# ENG-SF21021-R1-CD-GEC.pdf Markup Summary

RETREAT AT TIMBERRIDGE FILING NO. 2 CONSTRUCTION PLANS GRADING & EROSION CONTROL PLAN			
DESIGNED BY	PRA	SCALE	DATE 02-25-21
DRAWN BY	PRA	(H) 1" = 100'	SHEET 3 OF 24
CHECKED BY	(V) 1" = N/A	JOB NO.	1185.20

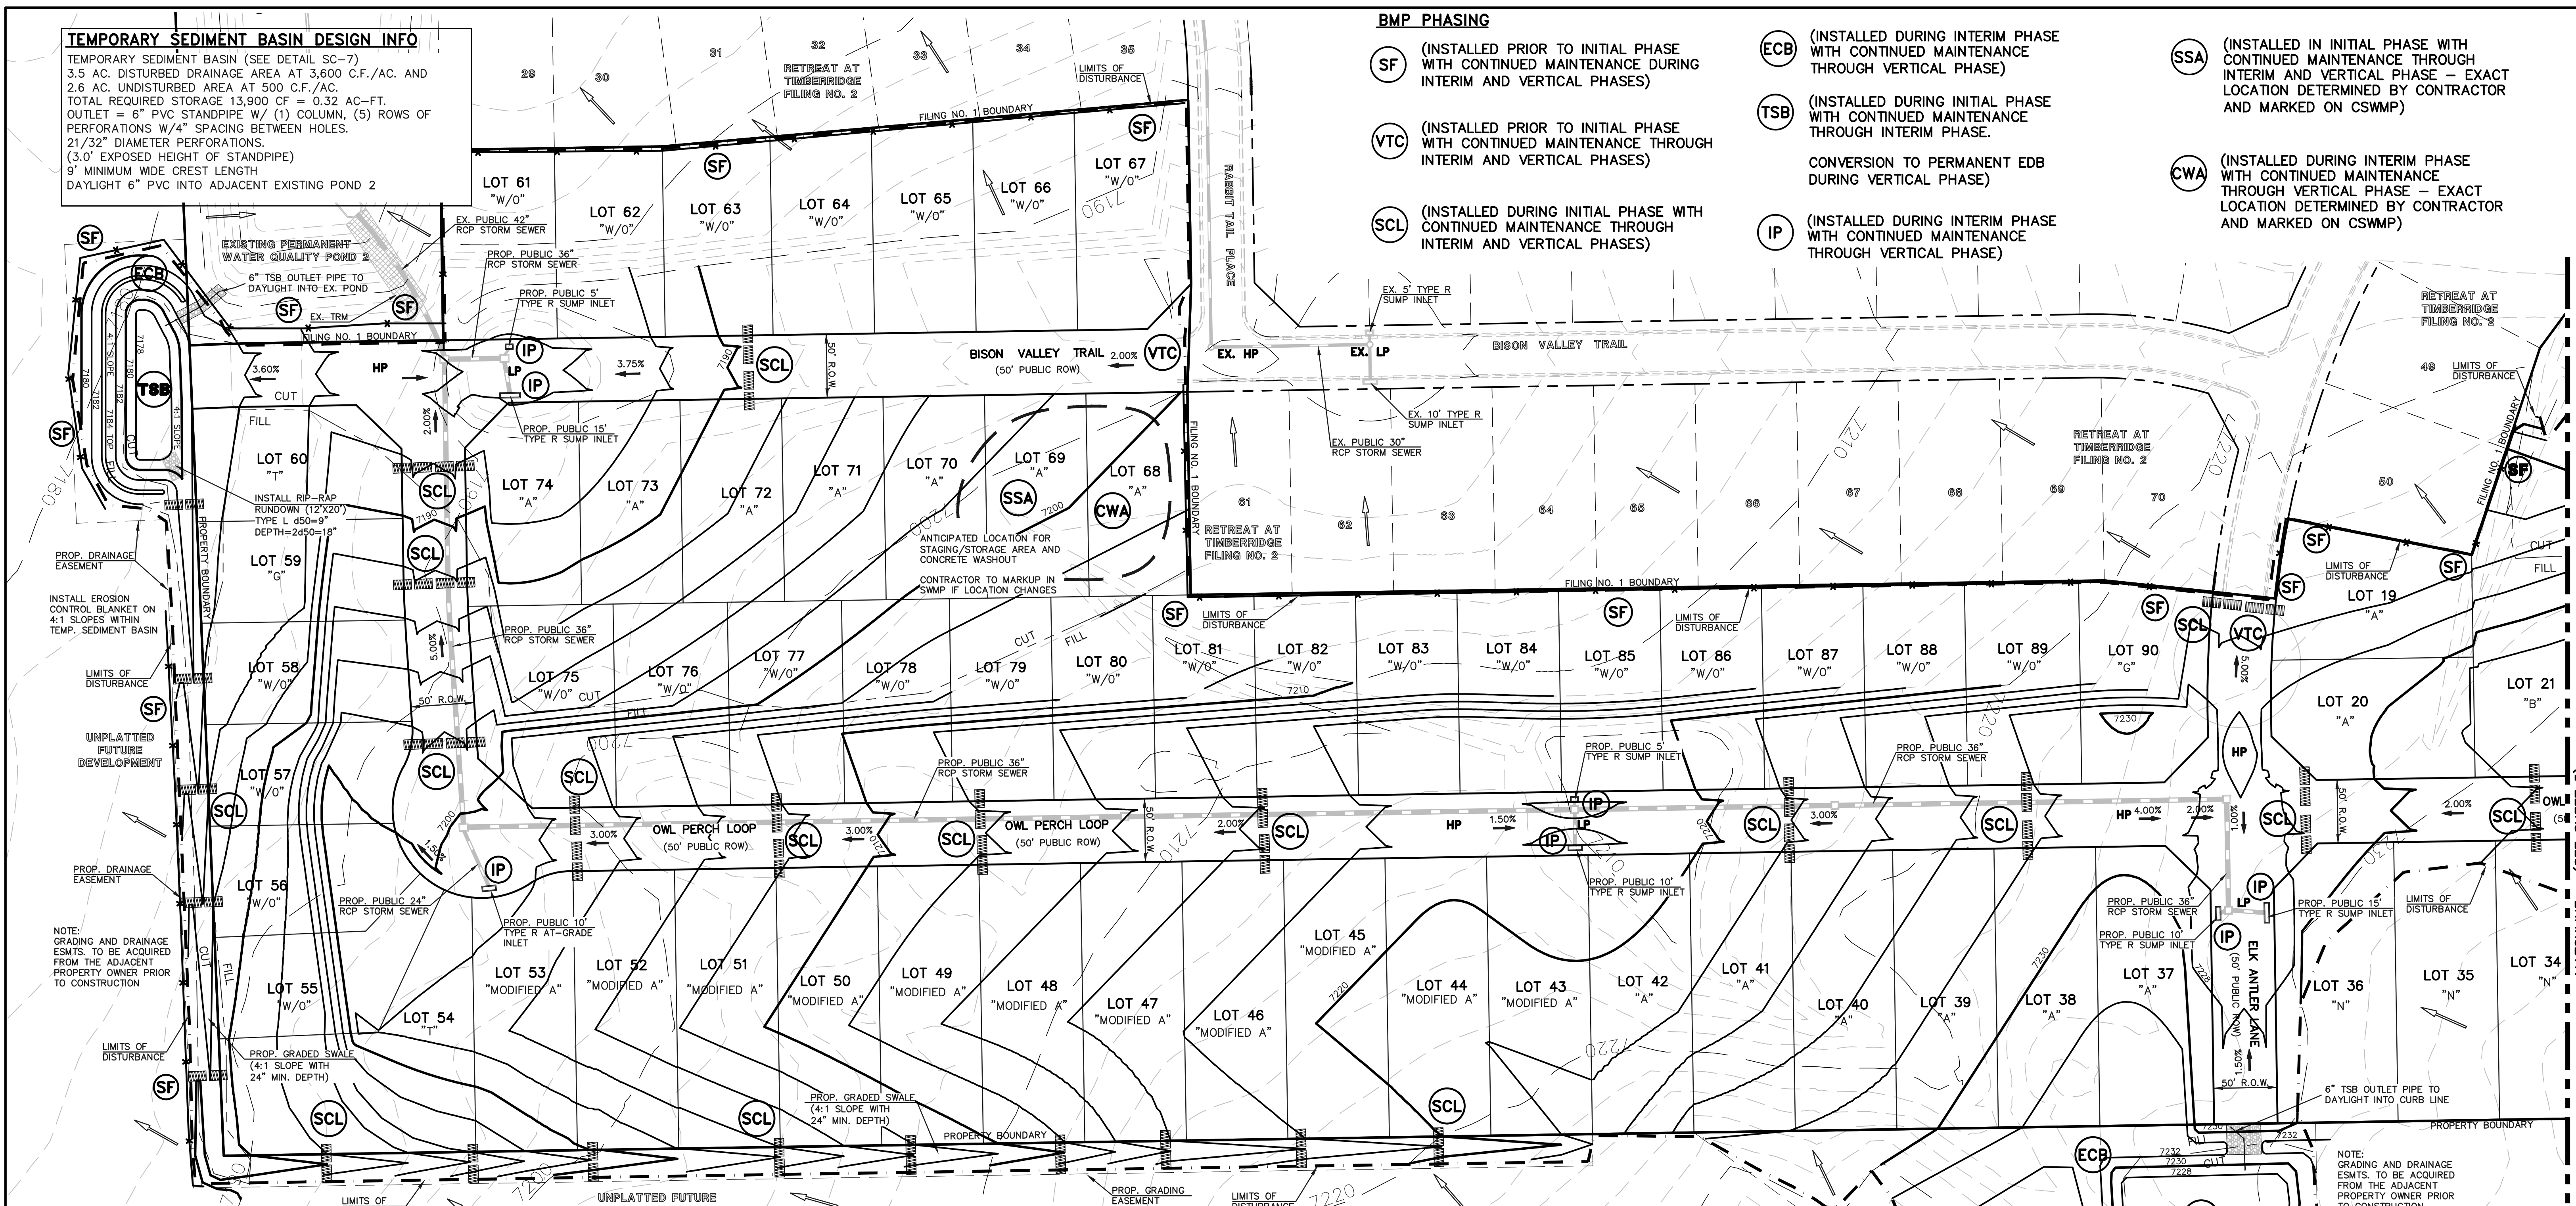
TRM or permanent lining?

Show and label wetlands

Private?

label slope

call out drainage easement and provide stormwater flow slopes in easement to determine if stabilization is required.

Show TSB proposed contours and provide details including riser pipe perforation sizing, number of rows, required volume, location of outlet and spillway, and tributary area to the sediment basin.

Call out drainage easement and provide stormwater flow slopes in easement to determine if stabilization is required.

Increase frequency of SBB. Should be installed every 1.5' of vertical fall

Label all proposed temporary construction BMPs by phase of implementation (initial, interim, final)

Provide erosion control measure details.  
 Show areas of cut/fill

add a note about existing vegetation conditions and percent cover.

add a note stating there will be no batch plants onsite.

show staging area, storage areas, stock pile areas onsite.

RETREAT AT TIMBER RIDGE FILING NO. 2
CONSTRUCTION DRAWINGS
STREET SECTIONS / EROSION CONTROL NOTES

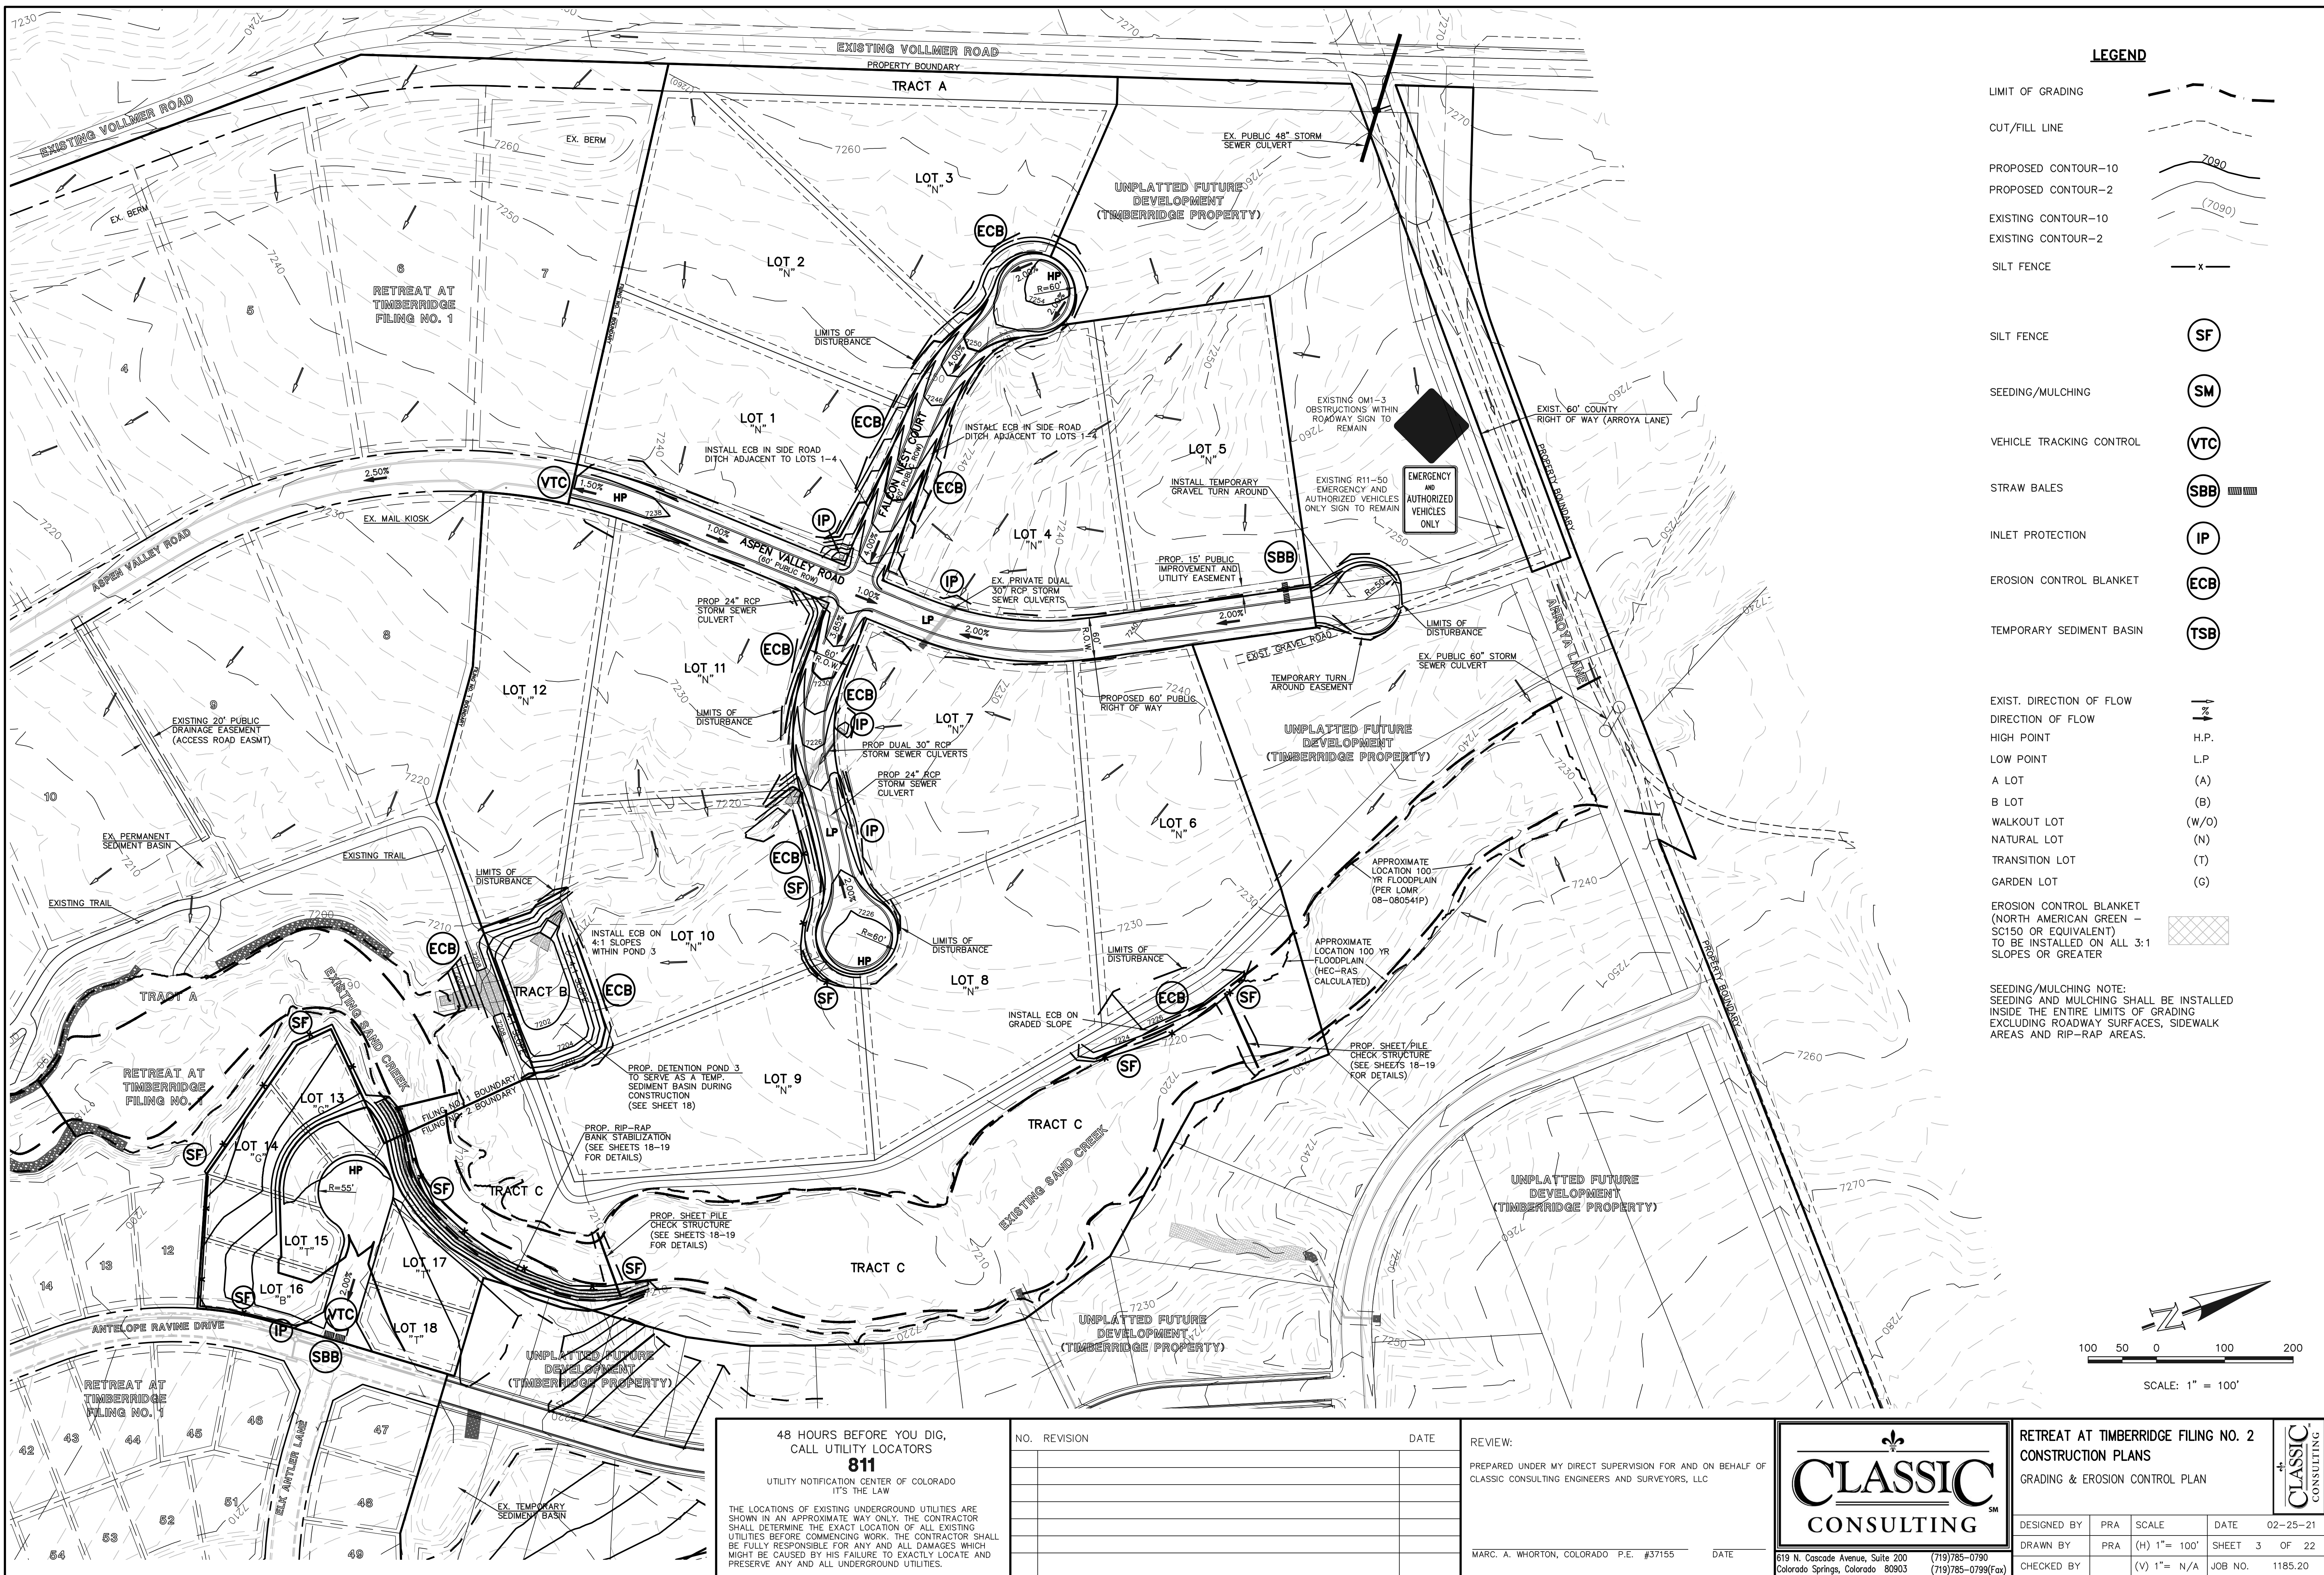
with watertight joints and Class IV concrete where called out.

RETREAT AT TIMBERRIDGE FILING NO. 2
CONSTRUCTION PLANS
STREET IMPROVEMENT PLANS
ELK ANTLER LANE

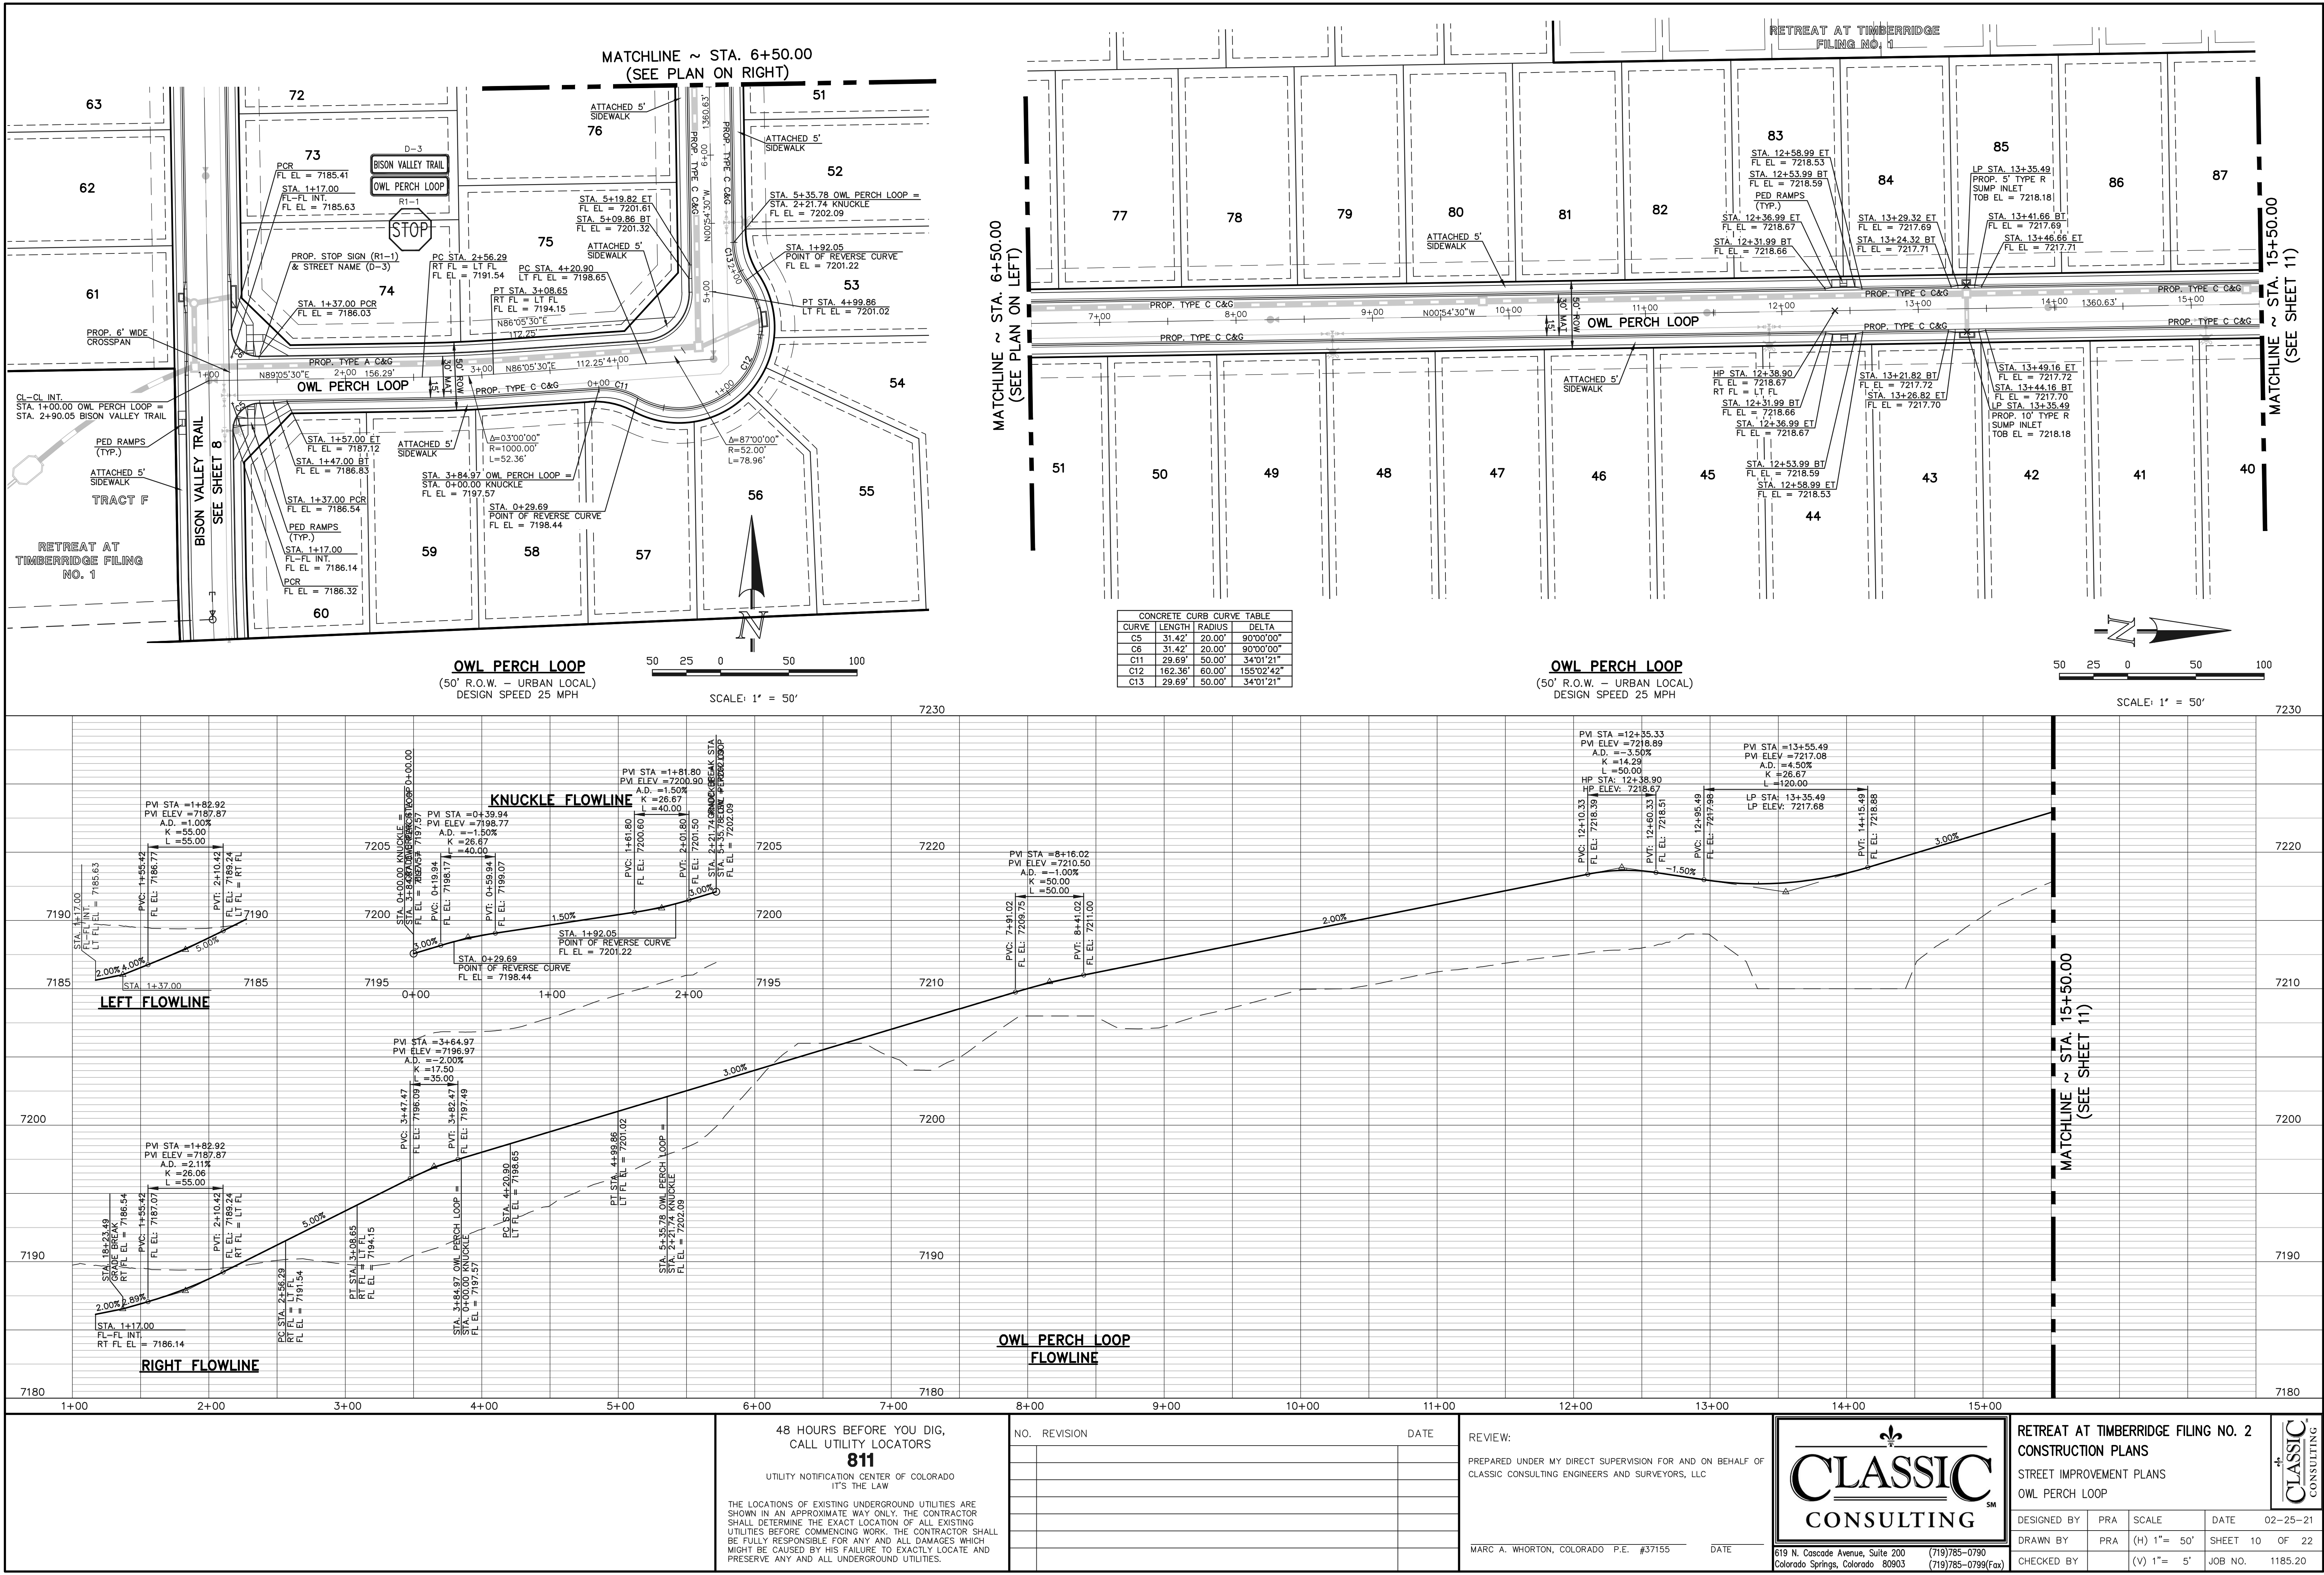
max. cul-de-sac grade is 3%

Label center of cul-de-sac

Show and label profile to center of cul-de-sac
